App No: Y/49/18/PL

Address: Land East of North End Road Yapton

Proposal: Development of 10No. residential properties & associated infrastructure. This application is a Departure from the Development plan

Environment Officer

Tree protection plan

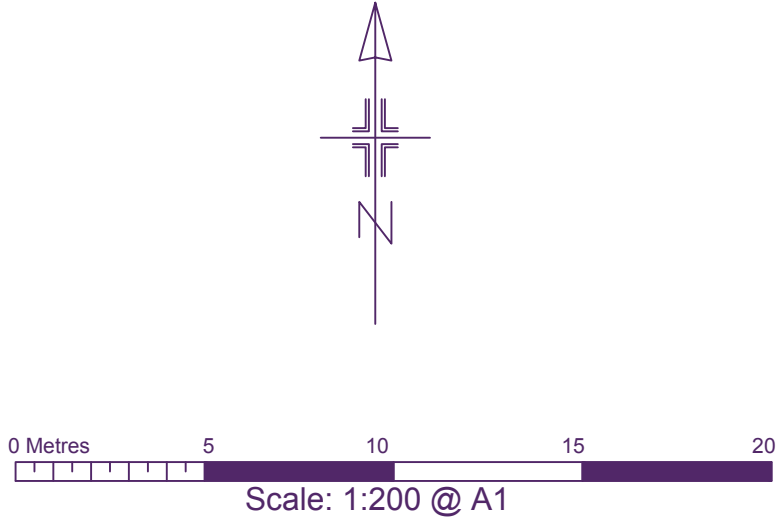
Any works to the trees or vegetation clearance on the site should only be undertaken outside of the bird breeding season which takes place between 1st March – 1st October. If works are required within this time an ecologist will need to check the site before any works take place (with 24 hours of any work).

- Any trees removed should be replace at a ratio of 2:1
- Filling any gaps in tree lines or hedgerows with native species
- Bat and bird boxes installed on the site
- Grassland areas managed to benefit reptiles.
- Log piles / bug hotel onsite
